From:
Sent: 12 December 2025 09:54
To: DC Admin
Subject: #Objection to Planning Application 2025/62/93287/W

Re: Formal Objection to Planning Application 2025/62/93287/W – Proposed Extension to 19 Smithy Way

1 02b GF Proposed
1 : 100

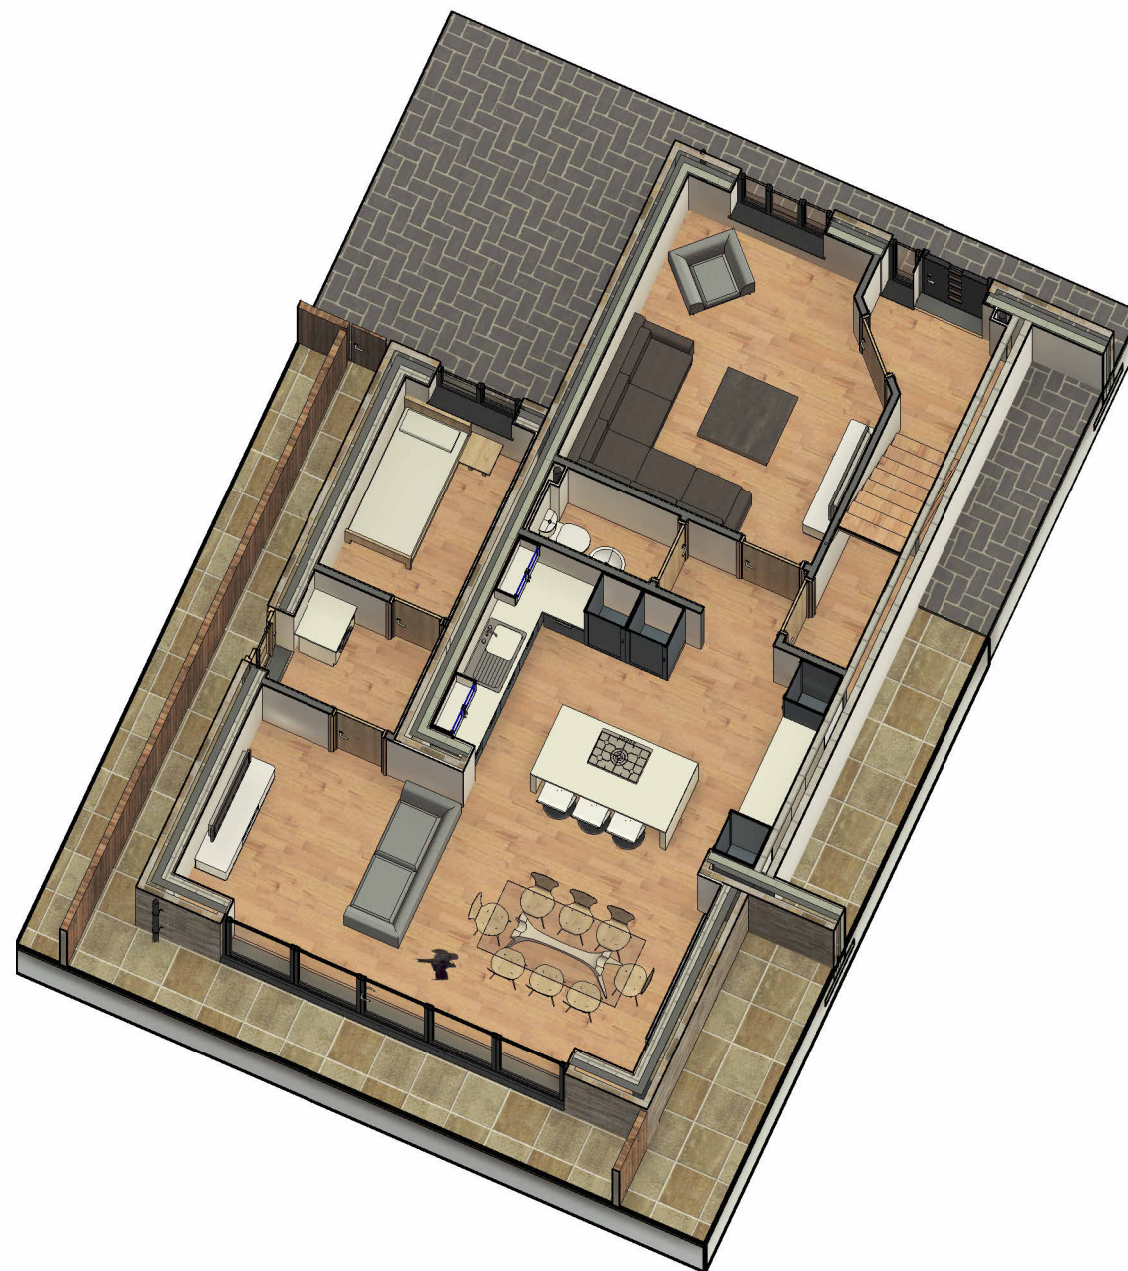
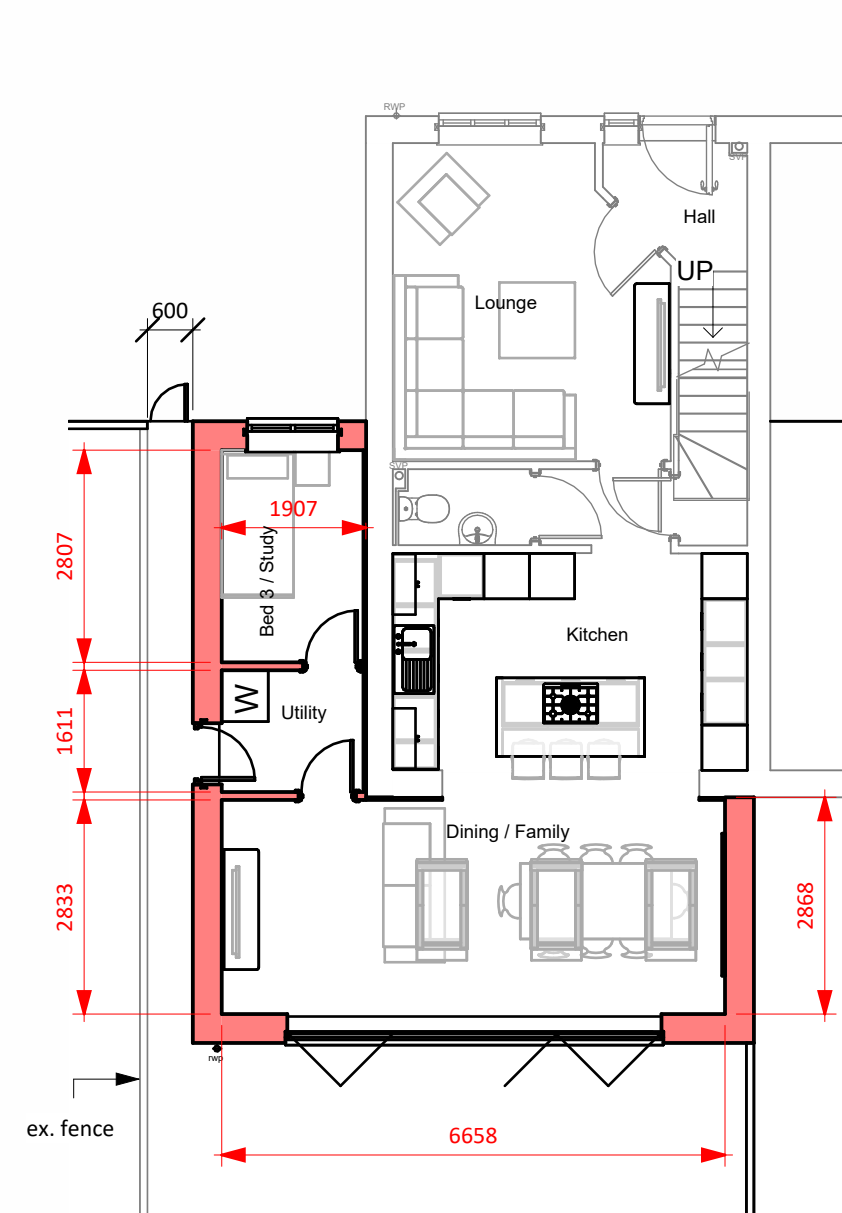
The plans indicate that the current boundary fence would be removed and replaced by the extension wall. This was not discussed with me, and I do not consent to the removal of this fence.

The fence clearly marks the legal boundary, provides essential privacy and forms part of the visual character of my garden, it sits on a 2ft retaining wall that is partly within my property, built by the original developers due to the gradient of the land.

Replacing this with a solid wall would significantly and negatively alter the appearance, outlook and ambience of my garden. It also raises questions about how a new wall could be built on a retaining structure that I partly own.

The extension is proposed to run over 9ft along the boundary. As mentioned the neighbouring property is higher than mine so the roofline of the extension (starting below their first-floor window) would appear even taller from my garden.

This would create a very overbearing and dominating wall, resulting in significant overshadowing and a strong sense of enclosure. Policy point 4.20 specifically states that neighbours should not be left feeling “unduly hemmed in”, which is exactly what this proposal would cause. The outlook from my kitchen diner and garden would be severely compromised.

Point 5.6 clearly states that single-storey extensions should maintain at least a one-metre gap from the boundary. The current proposal does not do this.

For all the reasons above — overshadowing, loss of light, boundary issues, and the impact on my outlook and garden's appearance — I request that the plans be amended so the extension is set back by at least one foot from the boundary and the existing fence is retained.

**2** Proposed Section  
1 : 100

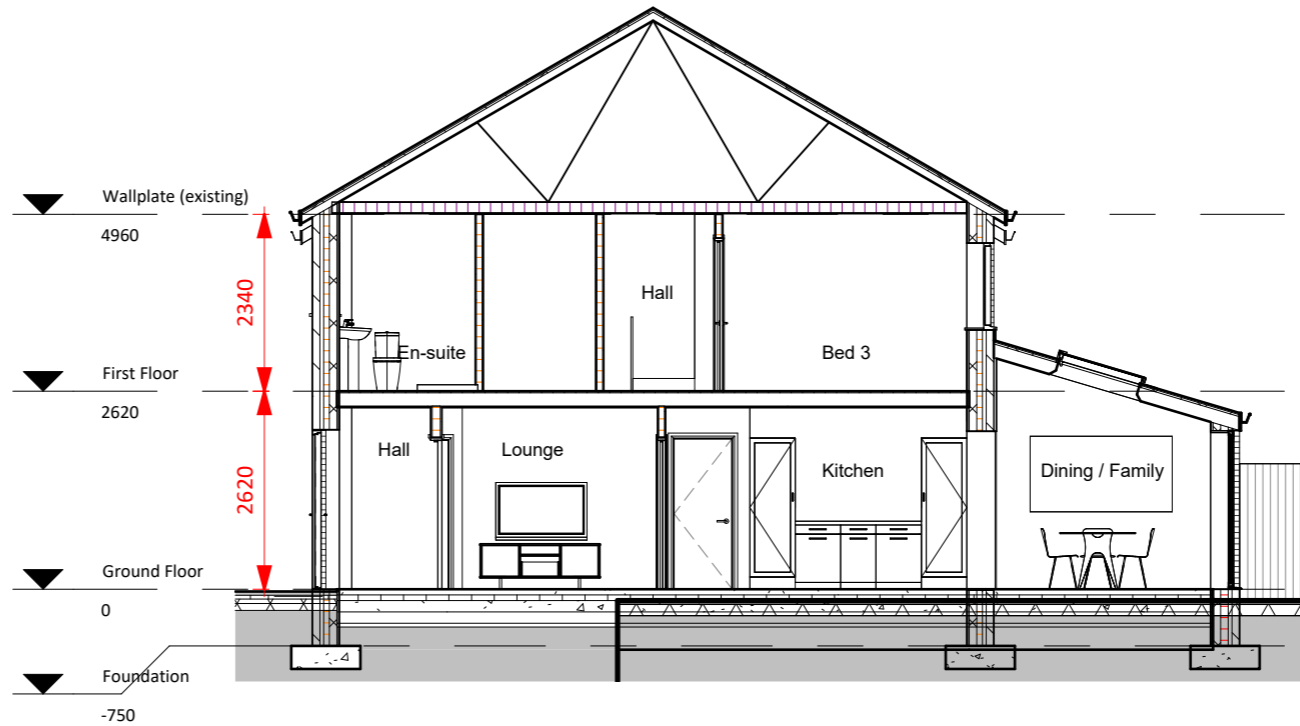
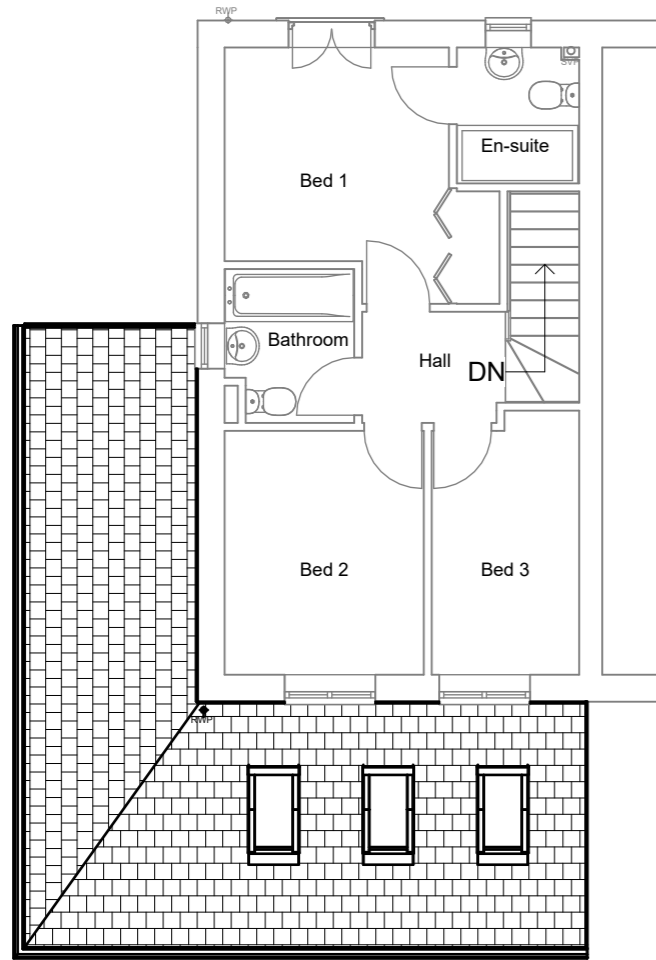
My home has two habitable rooms downstairs: the lounge and the open-plan kitchen/dining room where we spend most of our time. The kitchen diner window is extremely close to the boundary. As my property sits at a lower ground level to the applicants property, the existing fence already stands around 8ft high from my side (6ft fence on a 2ft retaining wall). The proposal shows that around 9ft 5in of this fence would be removed and replaced with a wall 9–10ft high, before adding the roof on top. Adding this to retaining wall currently in place would become a 10ft plus wall as my boundary and would significantly reduce the natural light reaching my kitchen-diner window and would almost certainly breach the 45° guideline used by the council to prevent loss of light to neighbouring habitable rooms.

The plans do not accurately show the existing levels. For example, Reference ID: 1116046 incorrectly shows a path on my side of the boundary — no such path exists. The fence actually sits on a narrow retaining wall, as shown in my photographs.

These inaccuracies raise concerns about how the extension could safely be built in the position shown, especially given that the retaining wall is partly on my land and owned by me.
